From: Graham Nicolls [REDACTED]
Sent: 11 August 2021 10:46
To: Kathryn Welch <Kathryn.Welch@arun.gov.uk>
Subject: RE: 54 Tarrant street Arundel

From: Martyn White <Martyn.White@arun.gov.uk>
Subject: RE: 54 Tarrant street Arundel
Date: 23 April 2021 at 17:30:33 BST

From: Karine Suhrbier [REDACTED]
Sent: 19 April 2021 10:44
To: Conservation Officer <Conservation.Officer@arun.gov.uk>; Martyn White <Martyn.White@arun.gov.uk>; Andy Waite [REDACTED]
Subject: 54 Tarrant street Arundel [REDACTED]

REAR ELEVATION - CHIMNEY AND WINDOWS 6, 7, 10 + 11

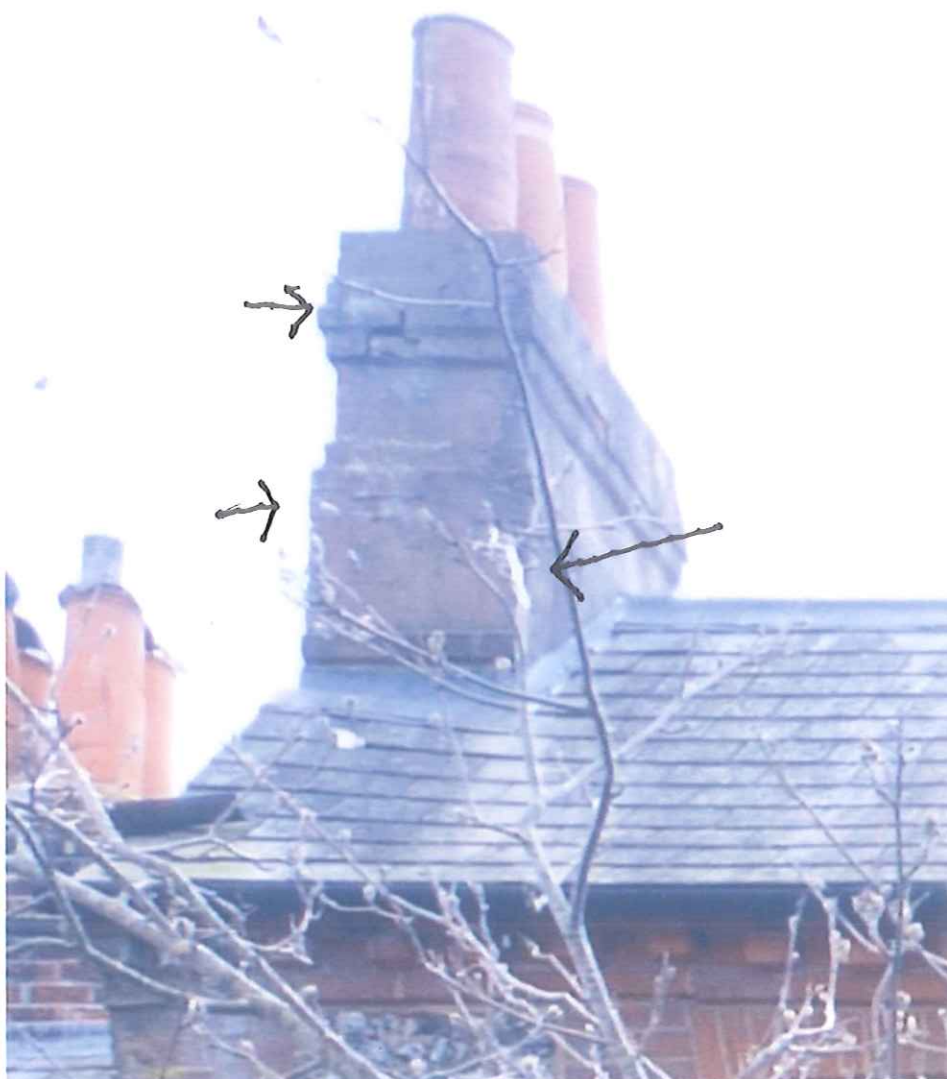
We have noticed for some time that one of our chimneys has needed some attention, and we have just had someone who specialises in this area, tell us that it needs taking down and replacing. So this is another thing I appreciate your thoughts on, is if we can just go ahead, as it is essentially a repair and all will be replaced like for like, or if we need to go for planning consent, or if we need full planning permission?

This will require Listed building consent, and as you state would have to be a like for like replacement i.e., in terms of the height, materials, appearance, detailing etc.

PROPOSED DETAIL FOR
WINDOWS W6, W7, W8 + W9
WHICH WILL BE DOUBLE GLAZED

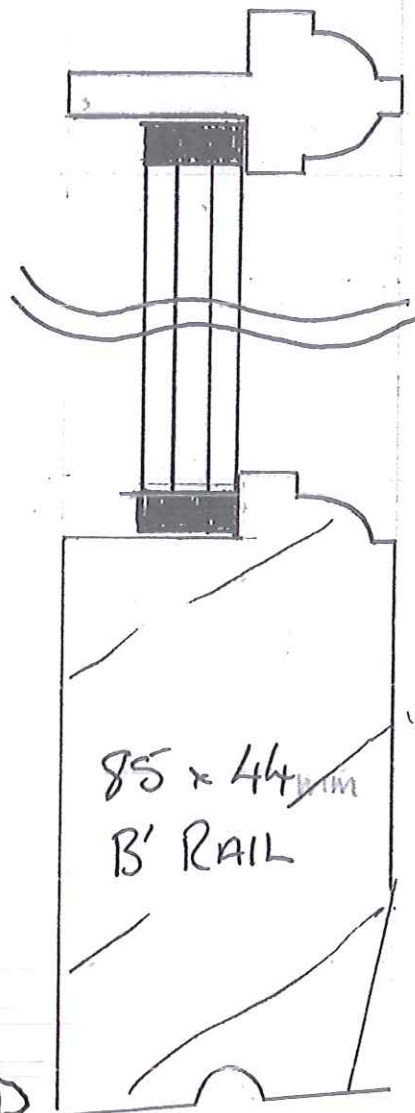
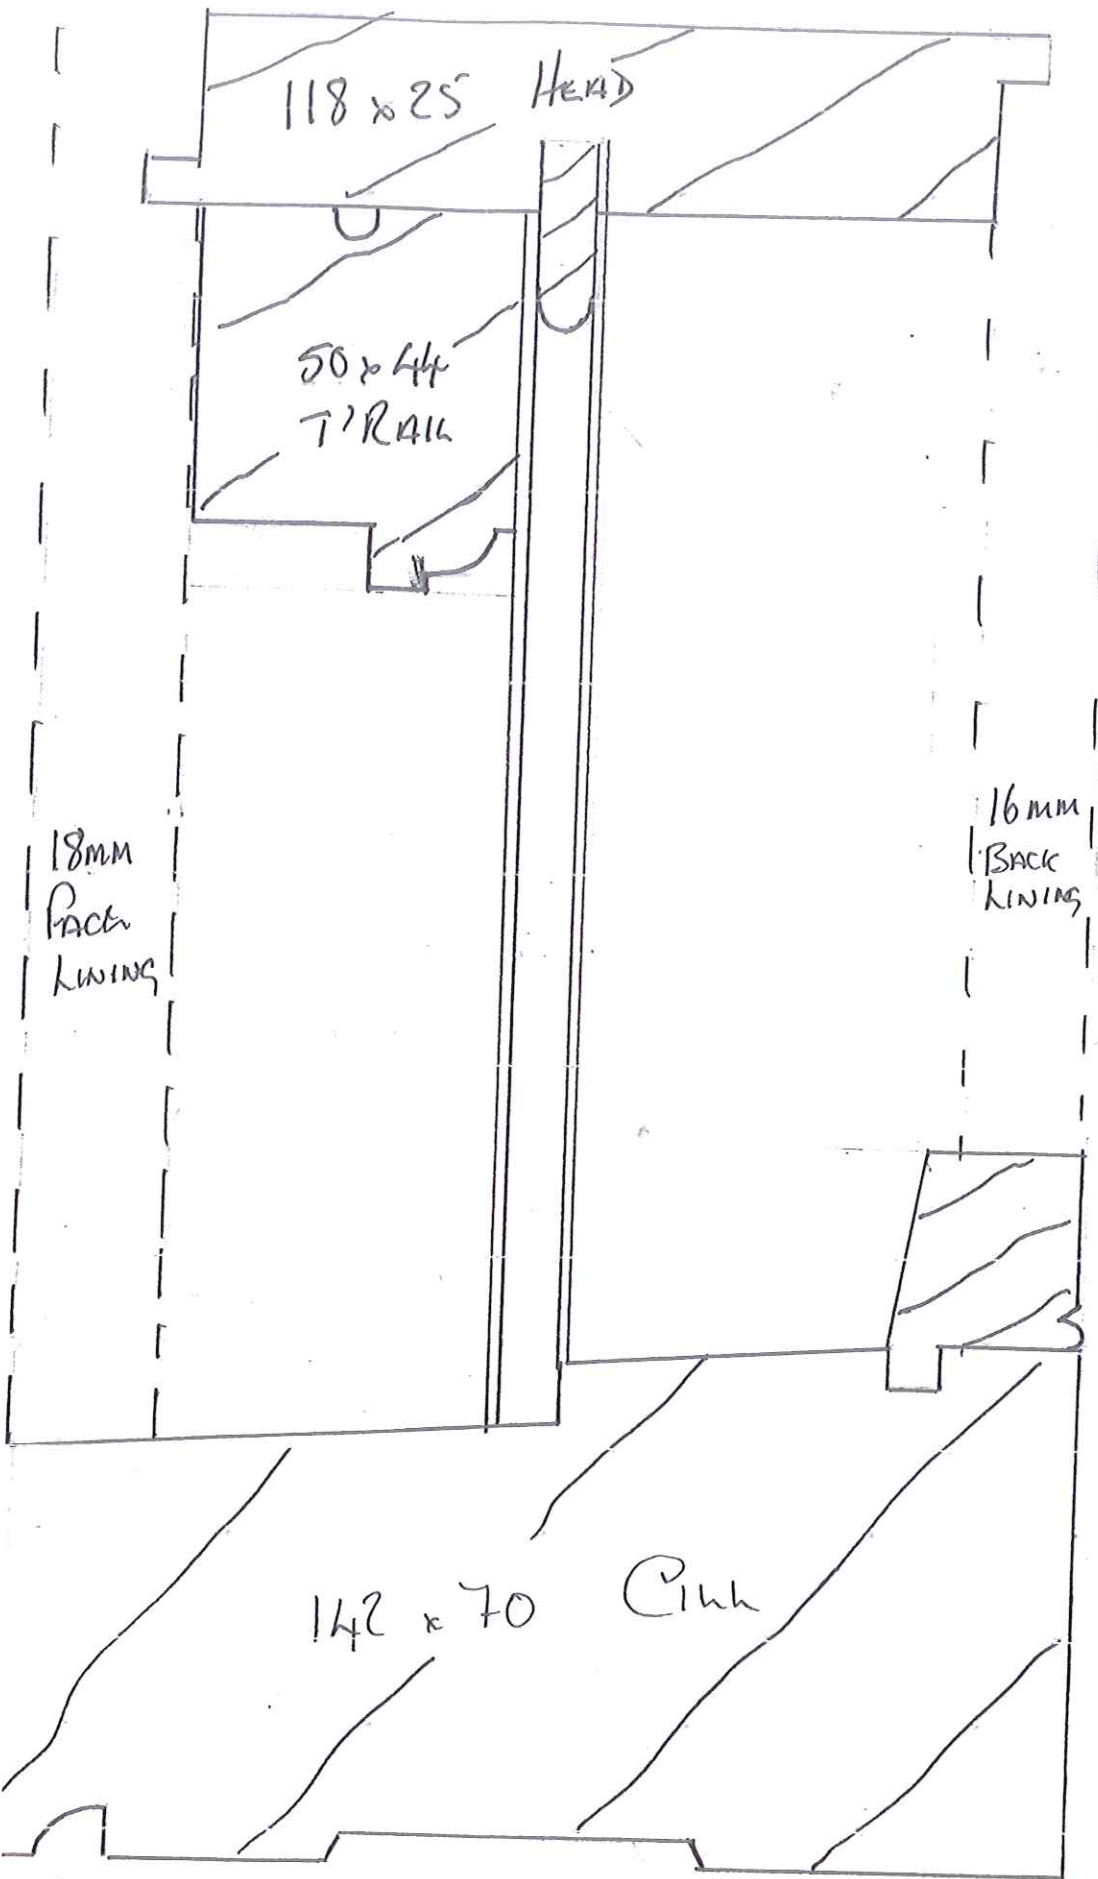
I wonder if you could give me your opinion on whether it is worth trying to get planning permission for double glazed units or if we should go for acoustic glass instead?

the glazing bars are 24mm x 44mm, and the windows will match the existing ones in all but that the new glazing bars are 2mm thicker than the old.

I have as yet not received any further communication about this. I wonder if you could give me your opinion on whether it is worth trying to get planning permission for them or if we should go for acoustic glass instead?

Double glazed units have been allowed in a limited number of properties in certain circumstances: the windows and the glazing were modern and did not affect the significance of the building. Ideally, the replacement windows would include single glazing as this is still best for the age and character of the listed building and area. However, as this proposal would only relate to the top floor, the impact would be lessened, and could be capable of support dependent upon the age of windows and the windows closely reflecting the existing, which I note you say would be the case.

W5
REPLACE FRAME + CASEMENTS
AND FIT ACOUSTIC REDUCING
SINGLE GLAZING

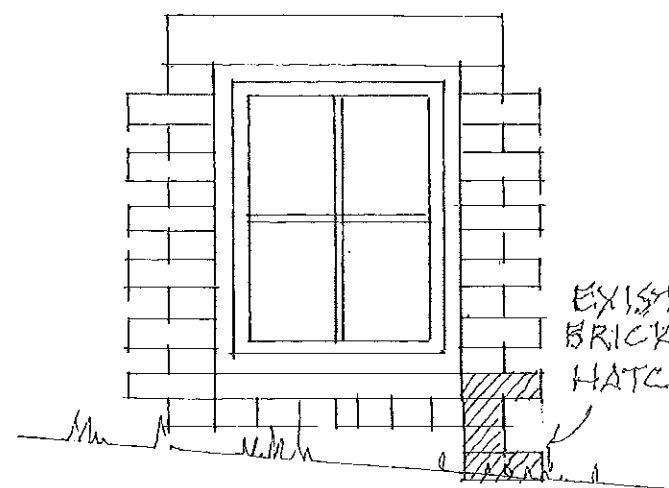
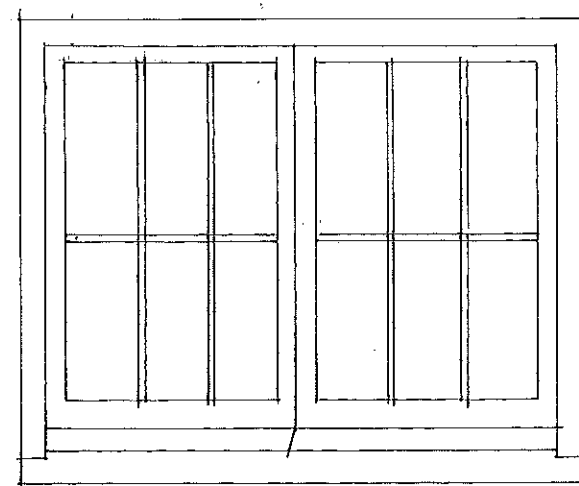
We also need to replace the two windows, the main window to the street, like for like, though using acoustic glass, and the side window from slatted to glazed and openable...design yet to be considered.

I would also state that if you were to replace the two basement windows (the main window to the street, like for like, though using acoustic glass, and replace the side window from slatted to glazed and openable), you would also need to apply for listed building consent, but this would be acceptable.
